CONSERVATION AND DESIGN

Reference Number	3/13/0542/LB	Date of Consultation	
Officer	Michael Chalk	Date of Response	10 May 2013
From	Sarah Leete-Groves

Site Address	The Moat House, Old Hall Green, Ware, SG11 1HE
---------------------	---

Drawing
 Proposed Elevations

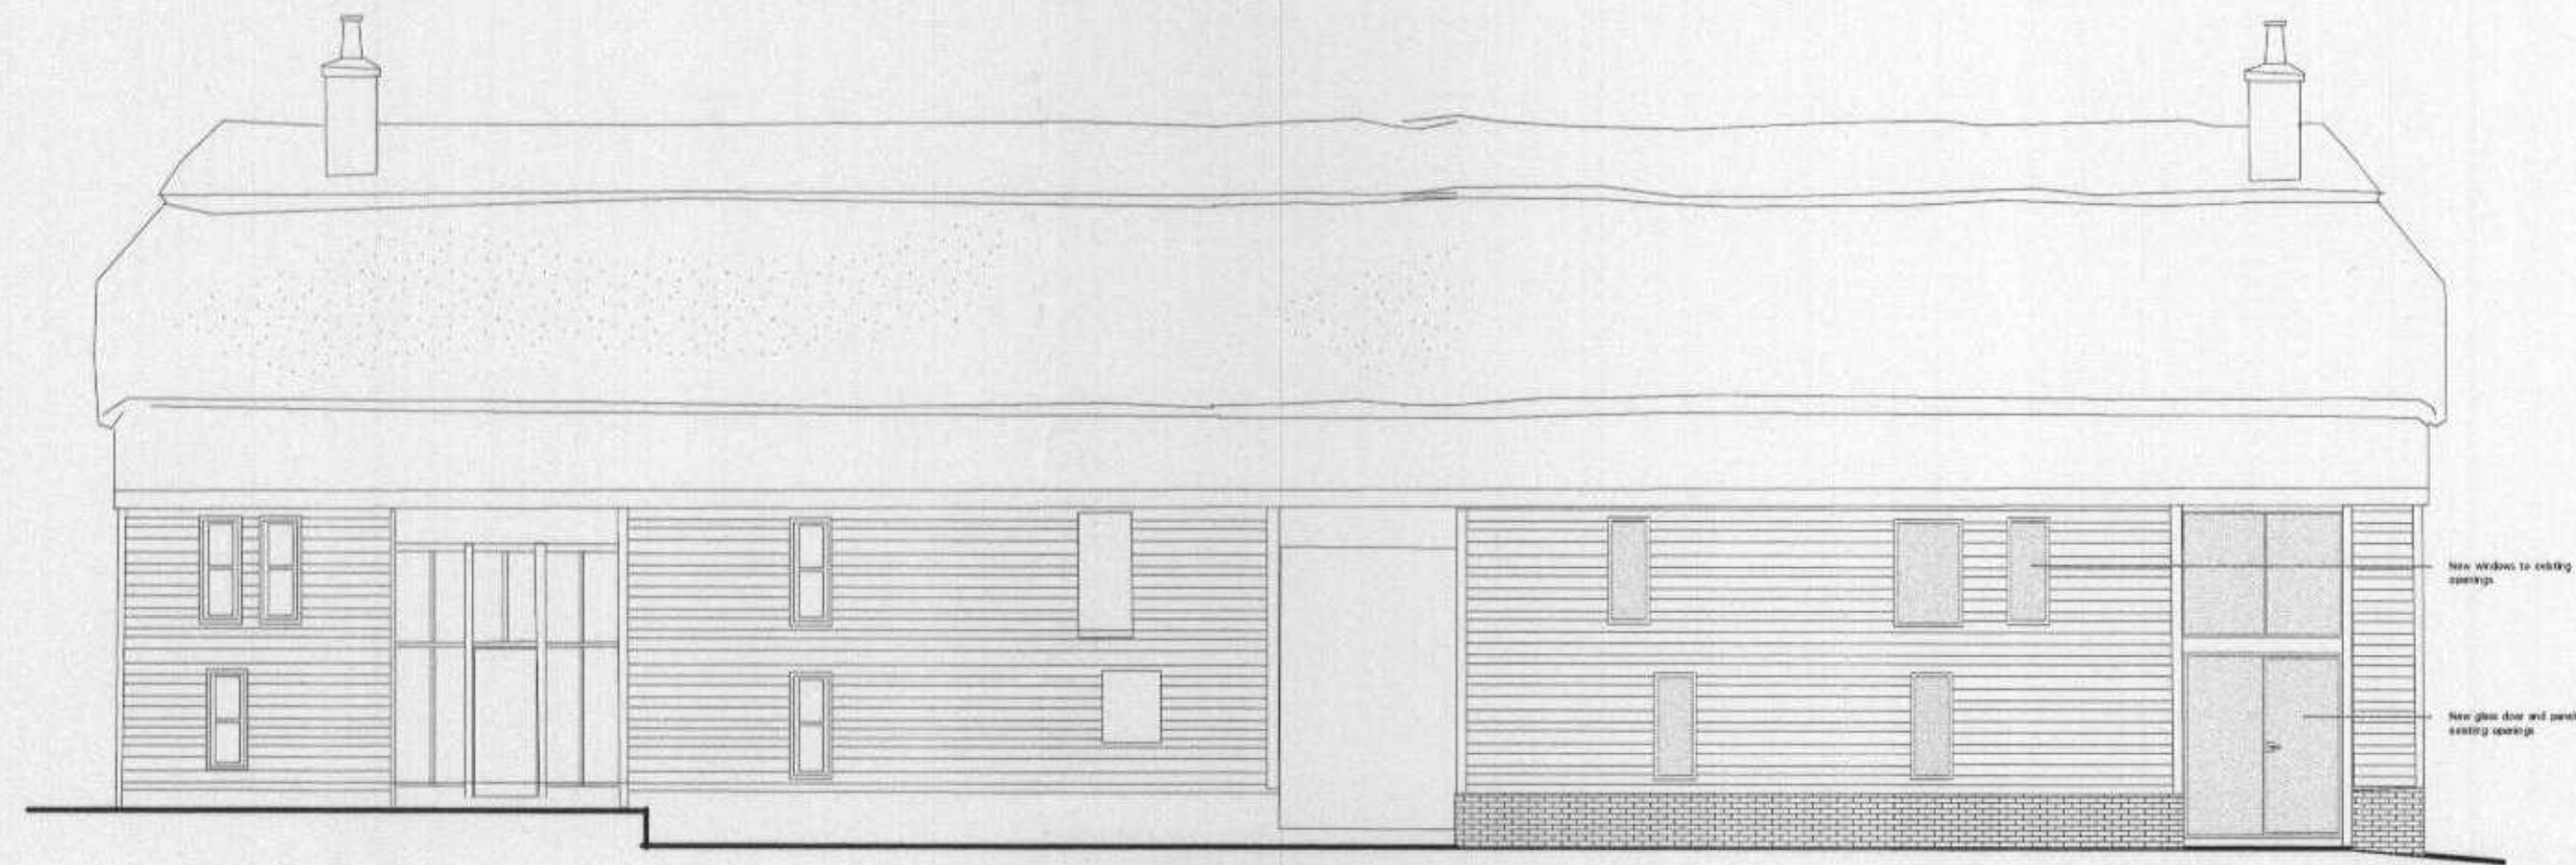
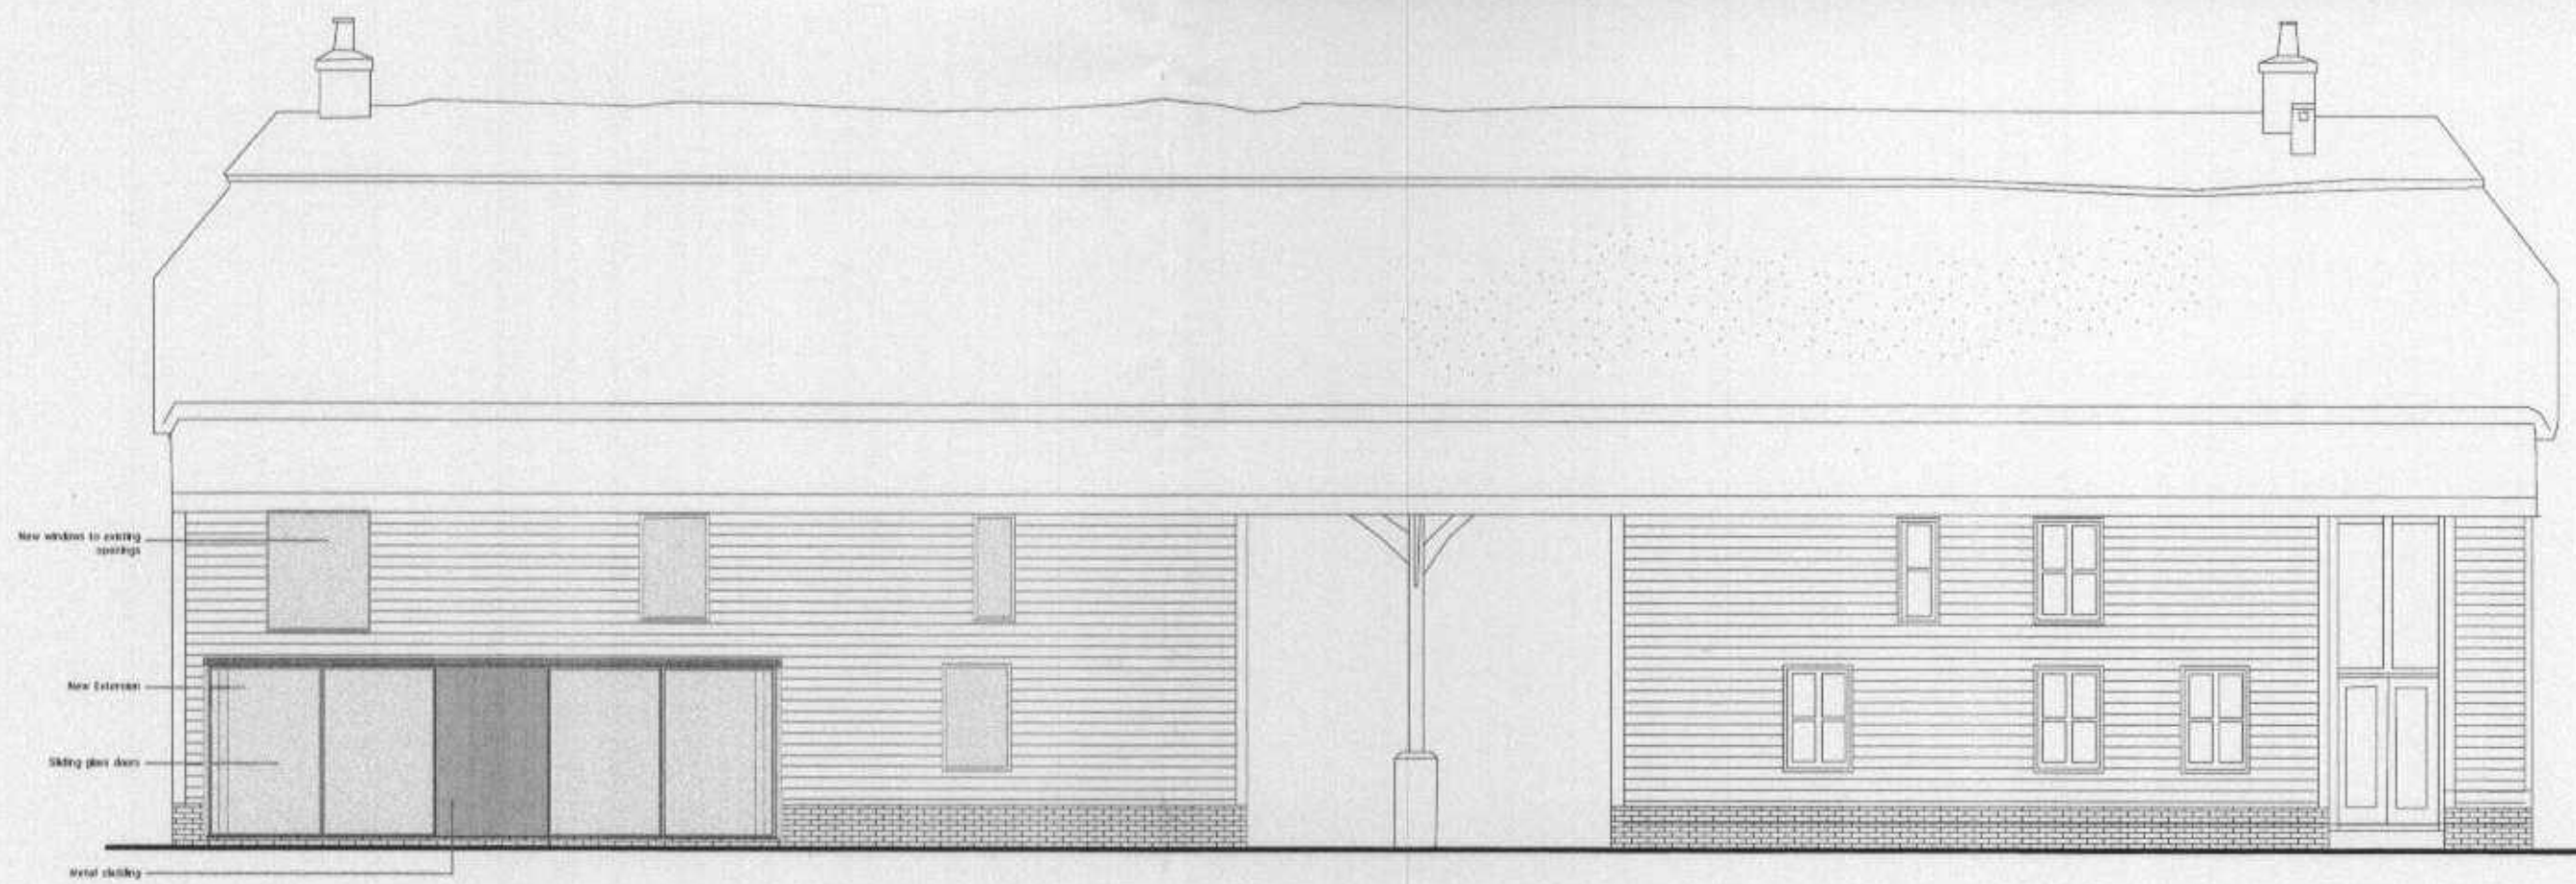
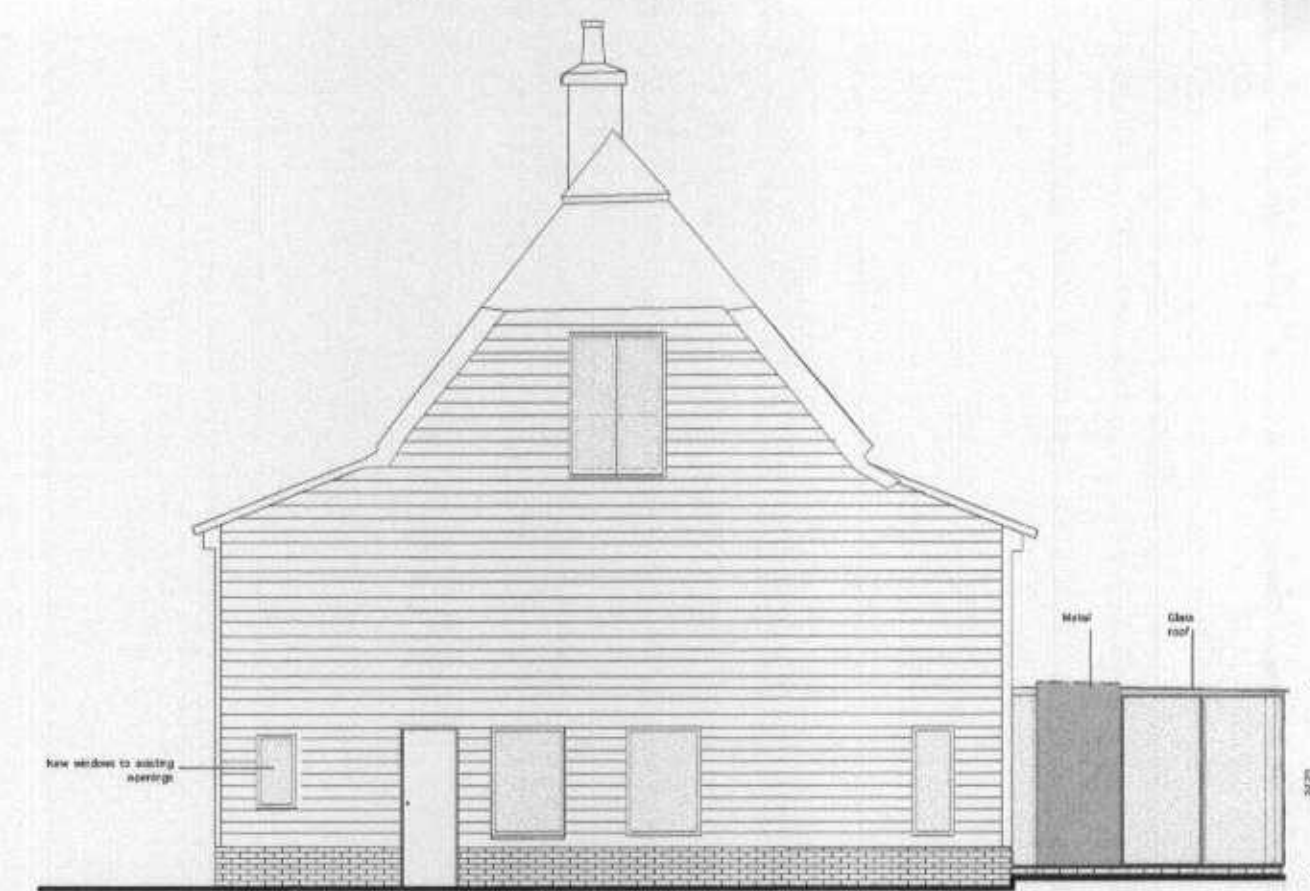
The proposed single storey extension is considered to have little impact on the significance of the listed building.
